From: Amanda Scholes on behalf of Planning.Responses
Sent: 07 November 2017 08:49
To: Planning Scanning
Subject: FW: WA/73/17/OUT - Land East of Wandleys Lane and West of West Walberton Lane, Fontwell.

Application No: WA/73/17/OUT

Site: Land East of Wandleys Lane and West of West Walberton Lane, Fontwell.

Proposal: Outline Planning Application with some matters reserved for up to 157 No. residential dwellings including 30% affordable. This application is a Departure from the Development Plan.

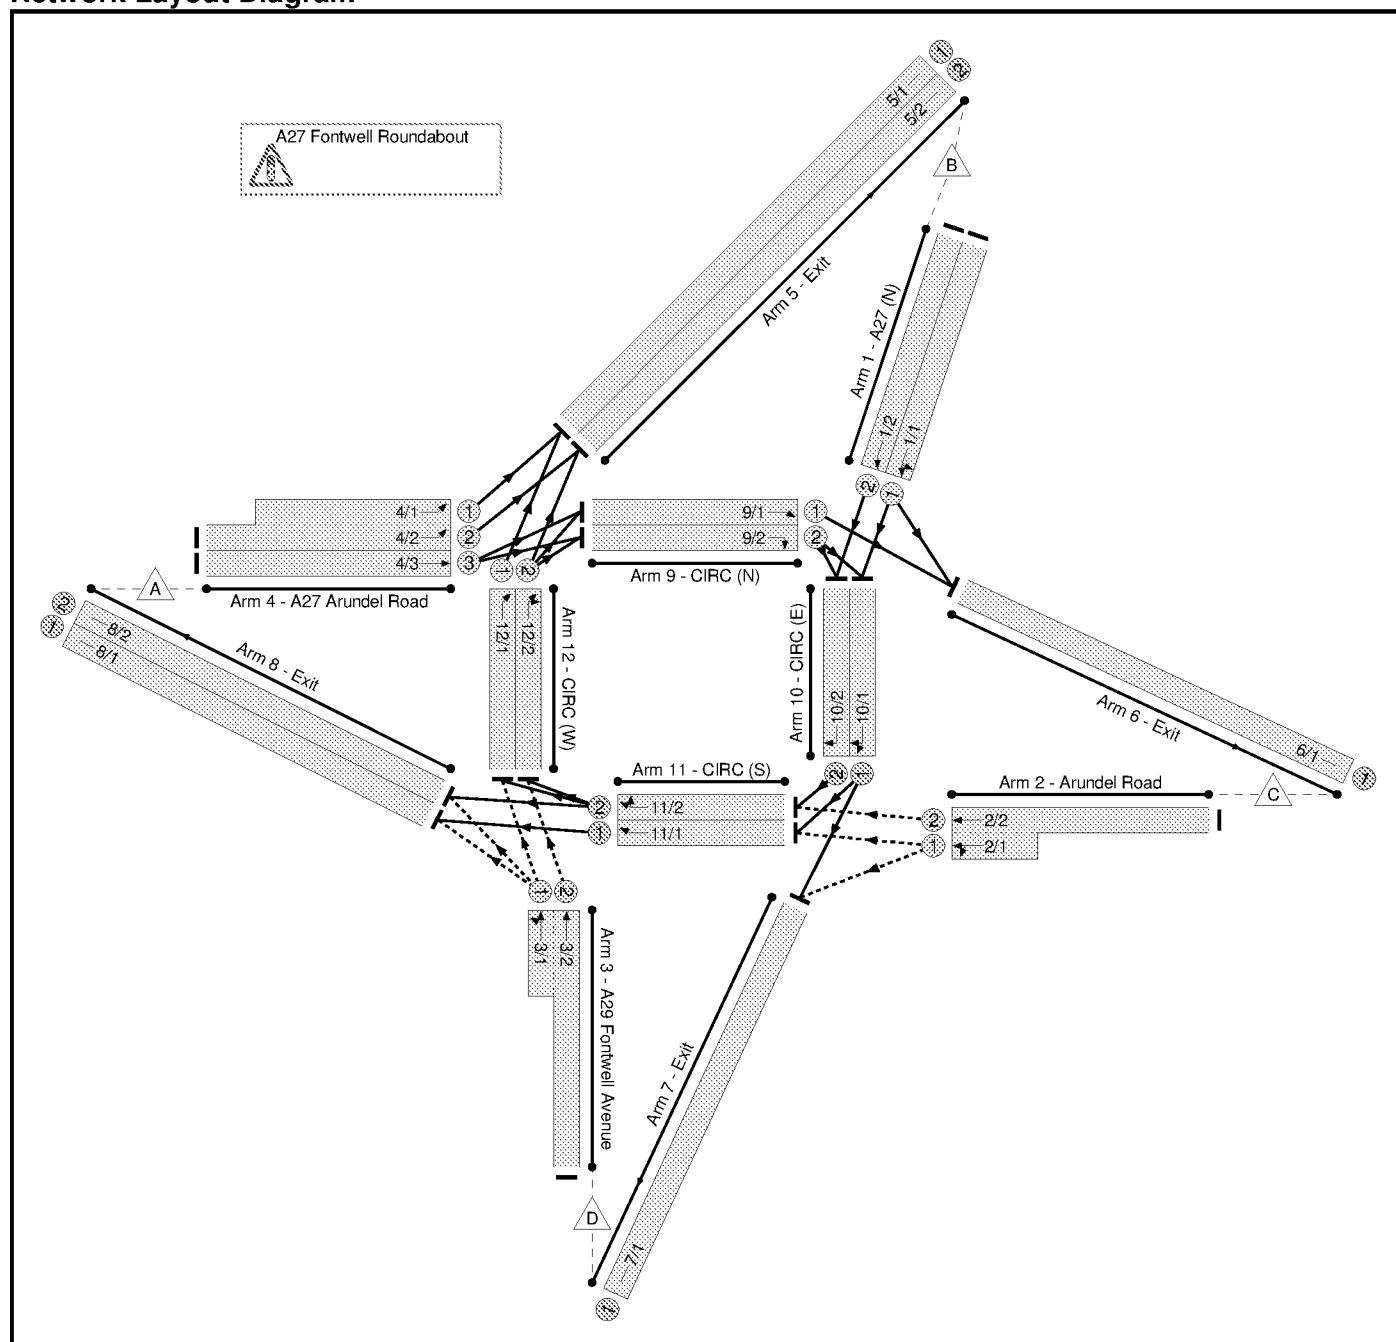
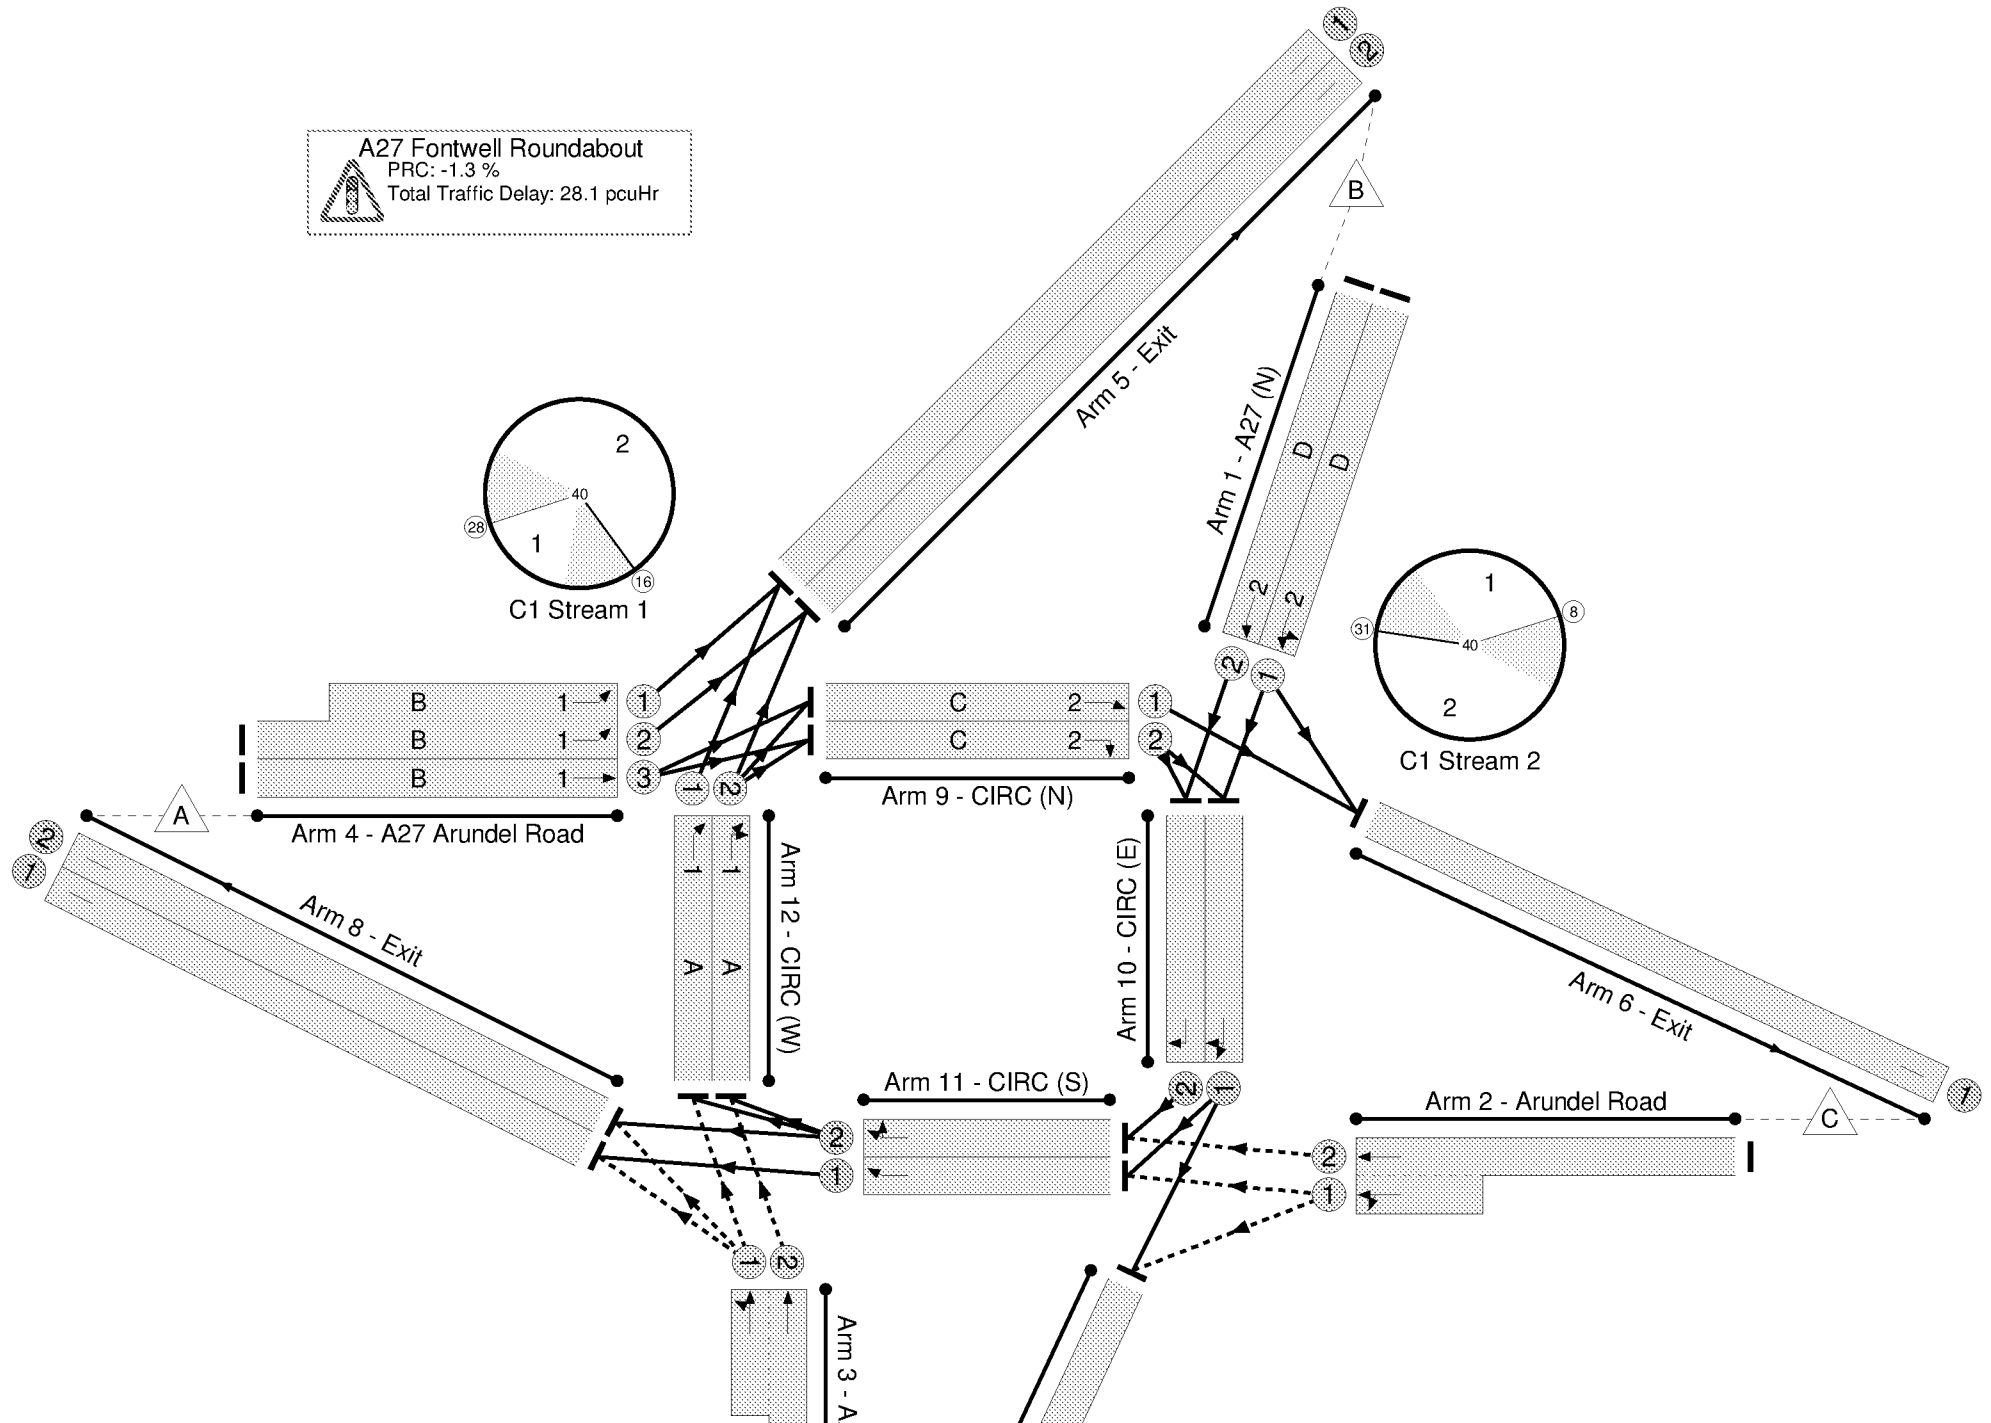
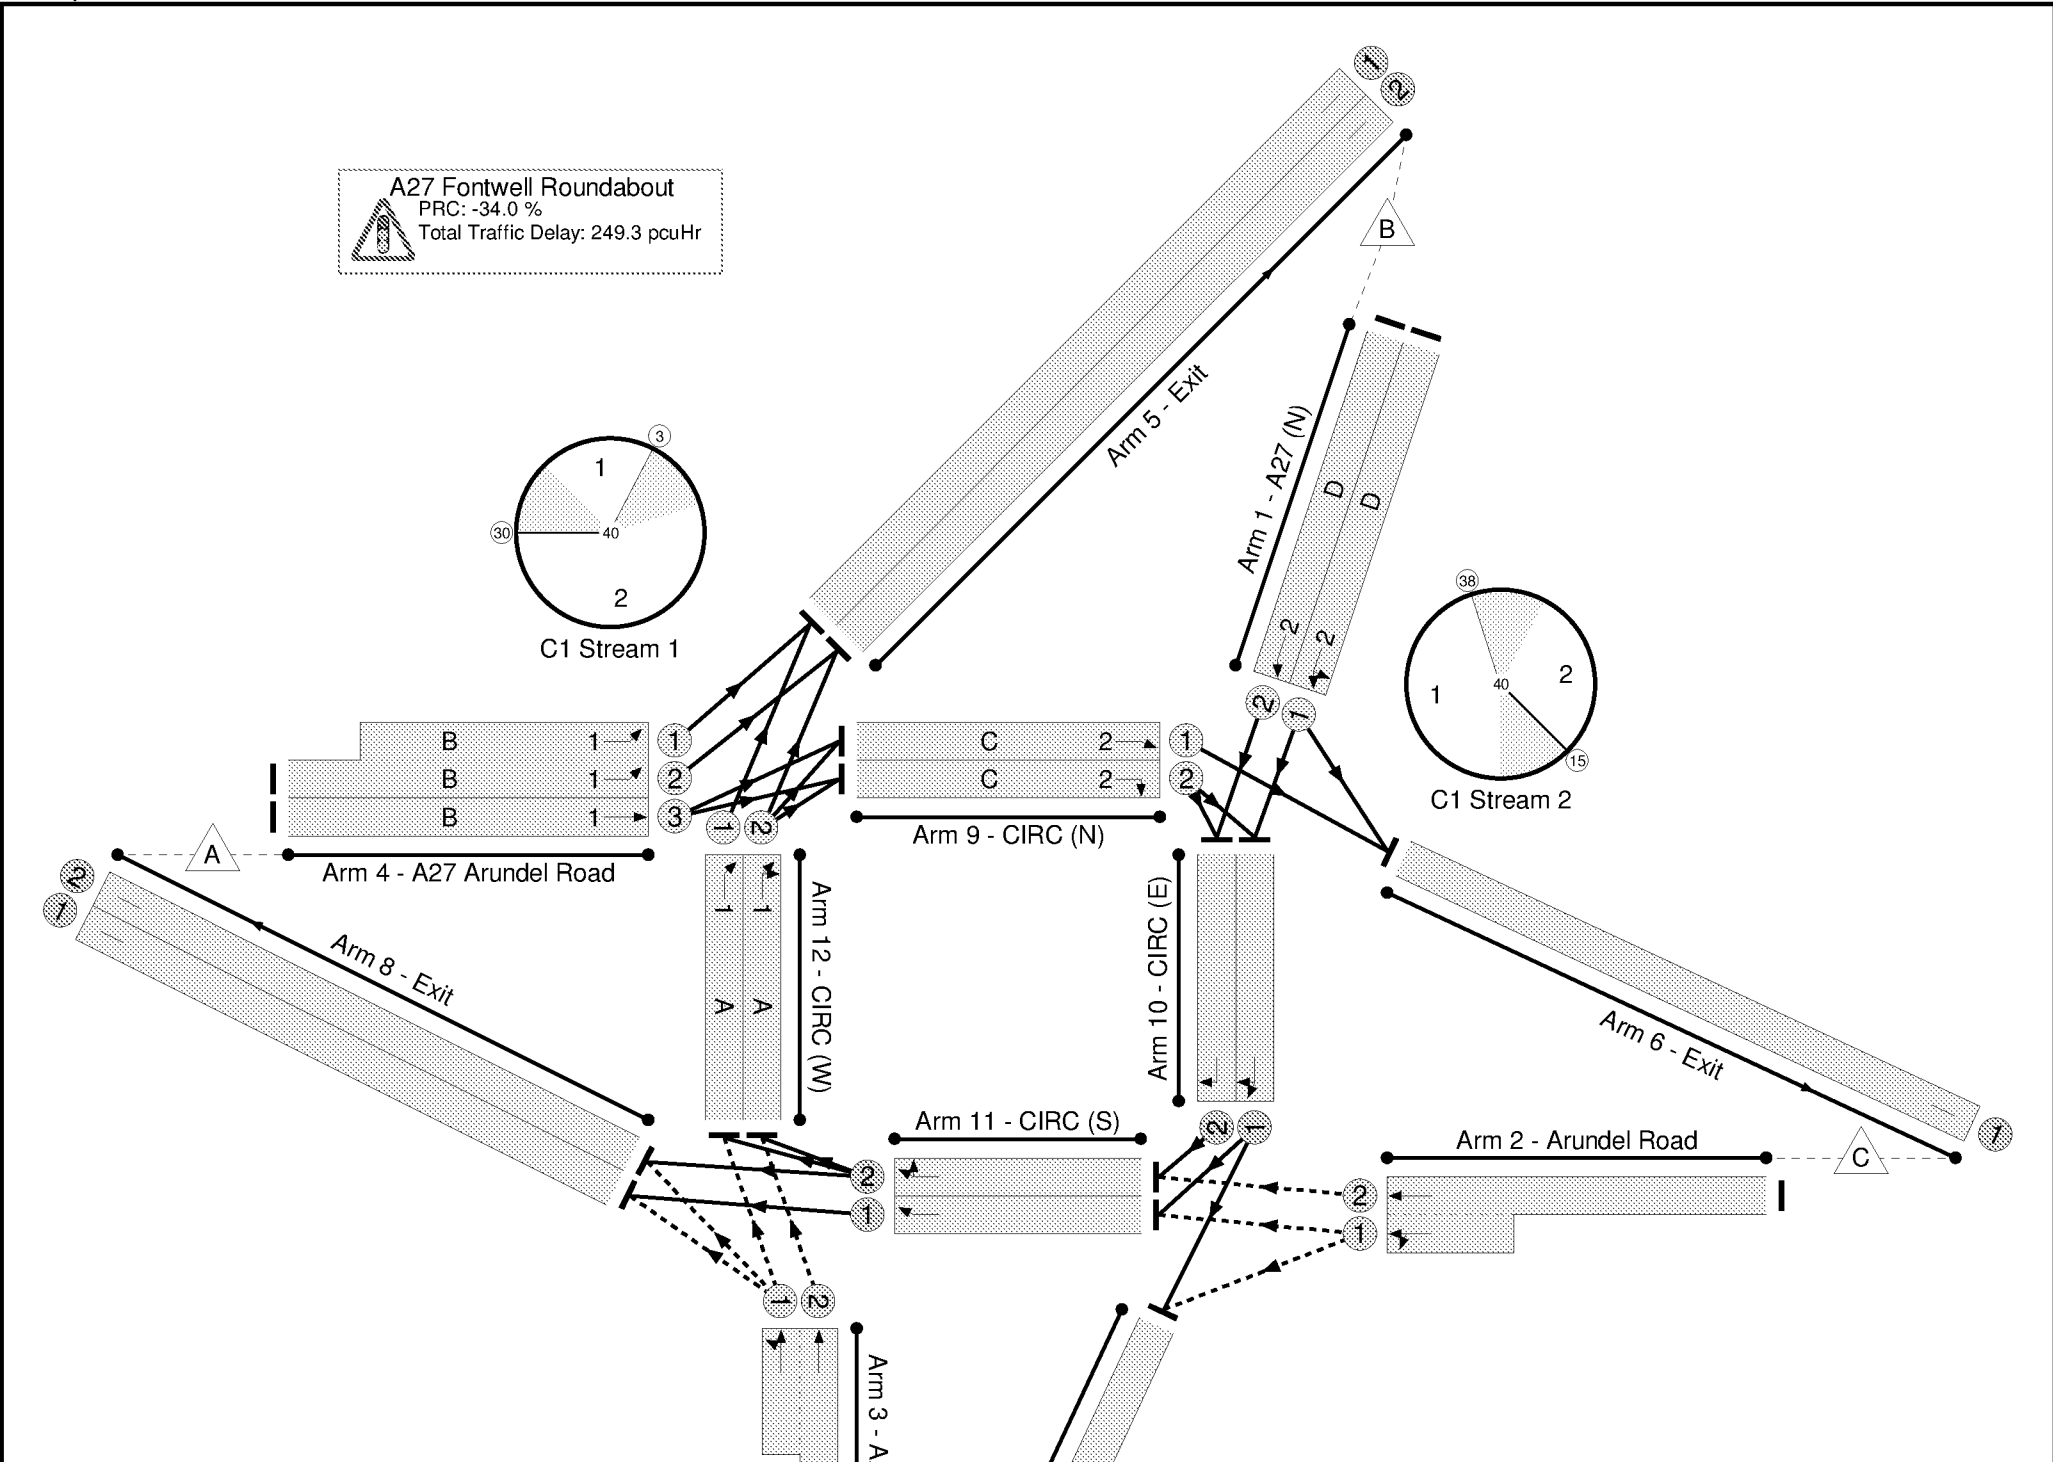
A29/A27 West Roundabout – LinSig – Proposed Signalised Layout

- The performance of some arms appear to improve after the development flows have been added in the tables on page 43 and thus clarification is sought on this:

- Arundel Road (E) arm in the PM peak
 - A29 Fontwell Avenue in the AM peak
- The modelling files are requested to make a full assessment of the modelling.

- Our initial analysis of the geometry suggests: Lane 2/2 's physical lane length in the model is too long. There is 127 metres to the next junction and the model has a lane length of 60 PCU. Lane 3/1's physical length seems to be too long, as it appears to be around 3 PCUs. Lane 4/1's physical lane length is too long, as it appears to be around 10 PCUs.

- All circulatory lanes are modelled as having a physical lane length of 60 PCUs, and thus this should be amended as it is incorrect, while a lane width of 5m for the circulatory appears generous.

- Clarification is sought as to whether saturation flows are geometrically calculated or directly inputted?
